# DISPLAY THIS CARD ON PRINCIPAL FRONTAGE OF WORK CITY OF PORTLAND

Permit Number: 070924

has permission to Demo Cottage

AT 661 ISLAND AVE, P.I.

SITE PLAN

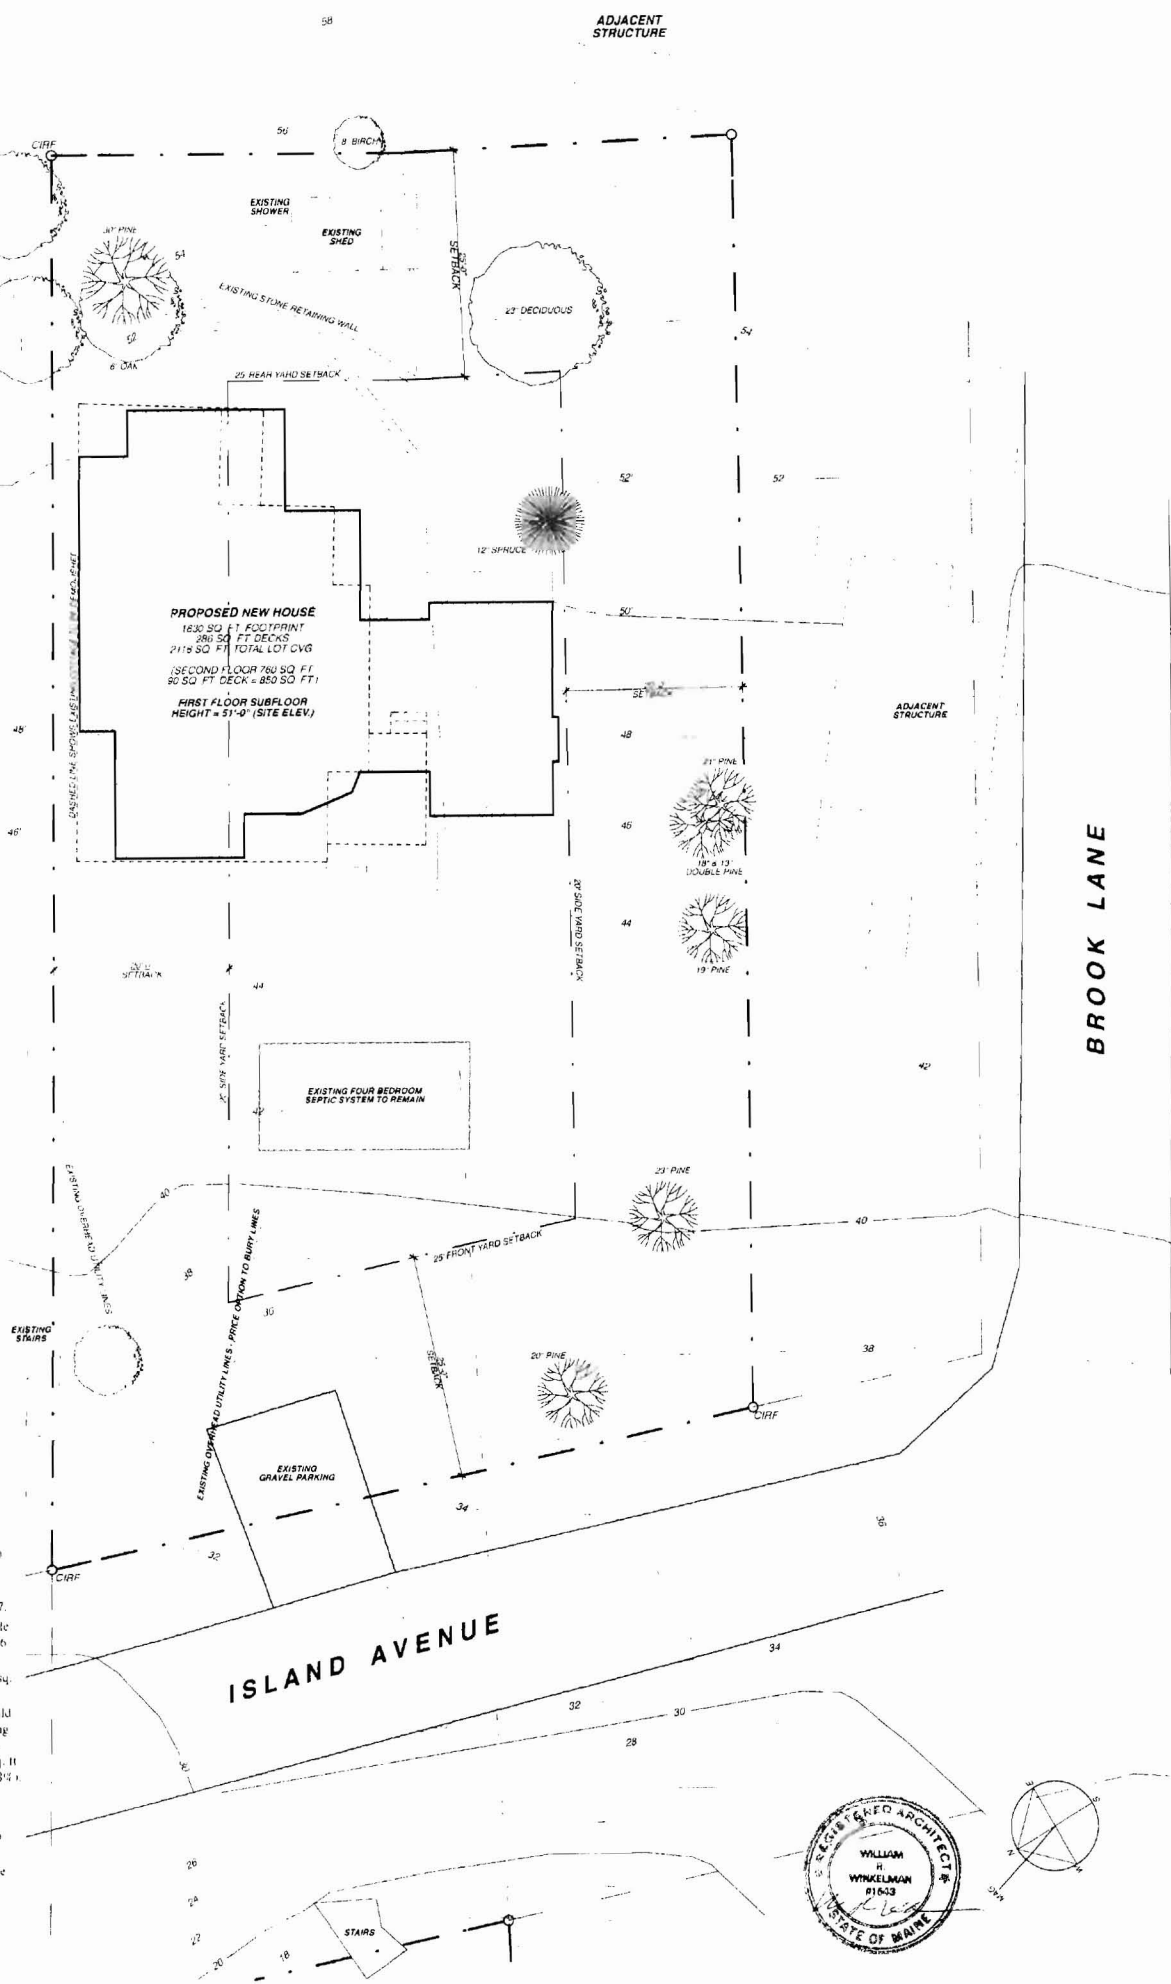
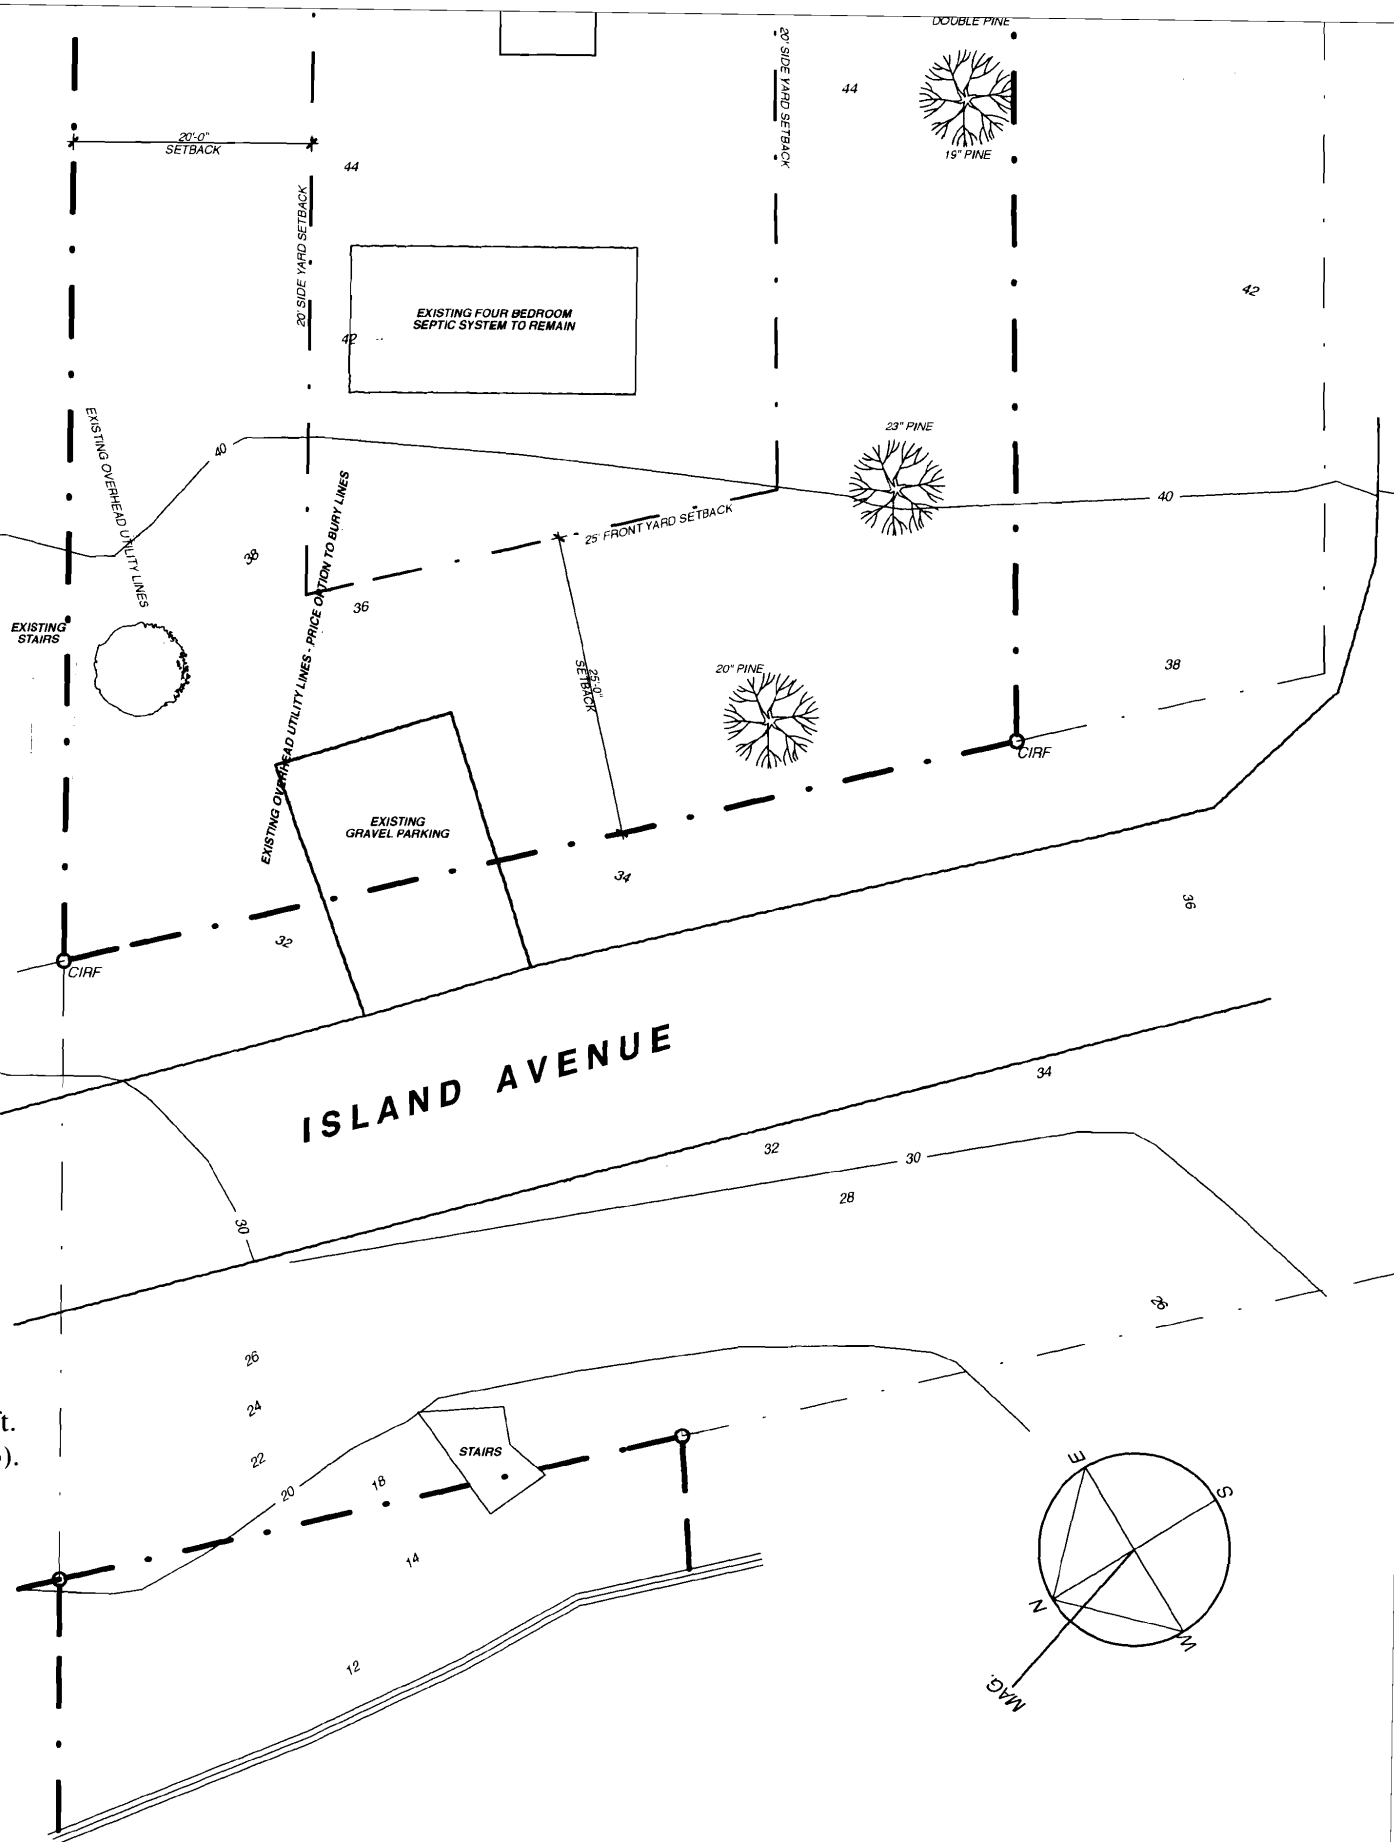
8/6/2007-mes: Called Leddy Houser - The application shows that they want to rebuild this new house - before demolition, I need to have a site plan where the existing building is located and where the new building is going to be located. I don't want to allow the building to be torn down and then find problems with their new house proposal. I want to know now so the property owner doesn't get "stuck".

8/10/2007-mes: received a site plan showing what is the existing building with setbacks and what may be proposed under a separate permit.
